Sent: 07 August 2018 15:36
To: Tracey Headley-Smith
Cc: 'Eamonn Campbell'
Subject: Ref AB/69/18/PL- BUTLERS RESTAURANT

I have seen the revised application which again includes the provision of plant for air and cooling to food storage to be placed on the flat roof very close to my bedroom window. I have also now seen the acoustic report which accompanies the revised application.

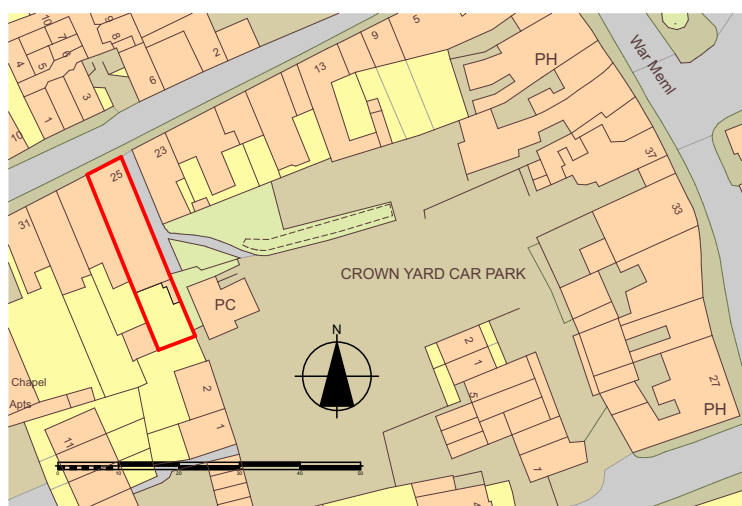
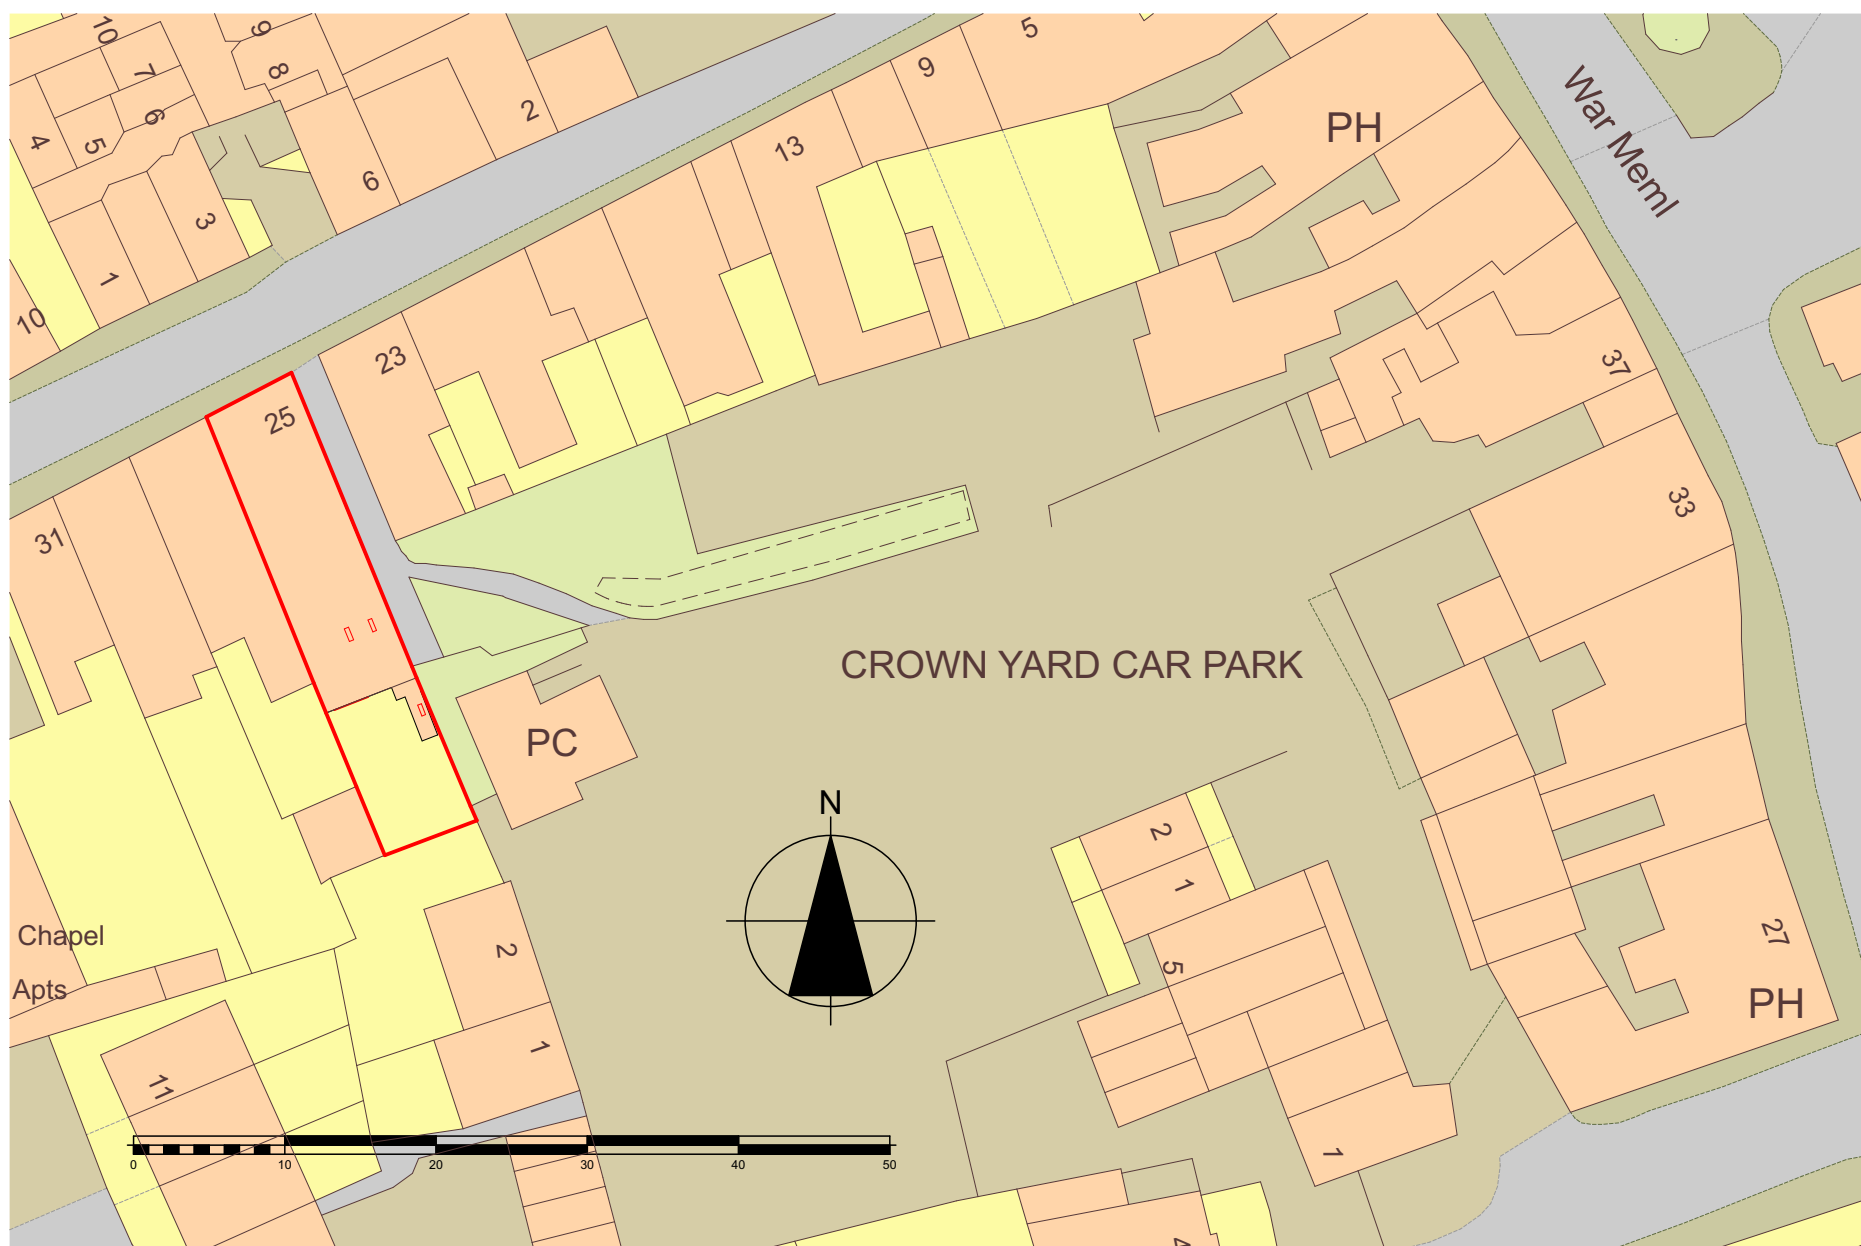
1. Despite the planning refusal the plant was installed and has been operational for many months.
2. Noise from the plant is clearly audible from my house particularly at night preventing normal sleep.
3. At the time of the last application your Environmental Health Dept. sought to undertake an acoustic test involving the setting up of sound equipment in the bedroom which is closest to the current plant. The owners of Butlers despite the prior arrangement refused them access to run the test so the assessment was abandoned.
4. The now supplied acoustic report has not seen any measurement from my property and appears merely to provide the sound output from the plant. It cannot have provided any assessment therefore of the actual nuisance.

I believe the plan is to remove a single item of the plant reducing the number to 2. If that is possible why is it not also possible to re-site the entire plant away from the close proximity of my house and not at such a high level where plainly noise will travel that much further.
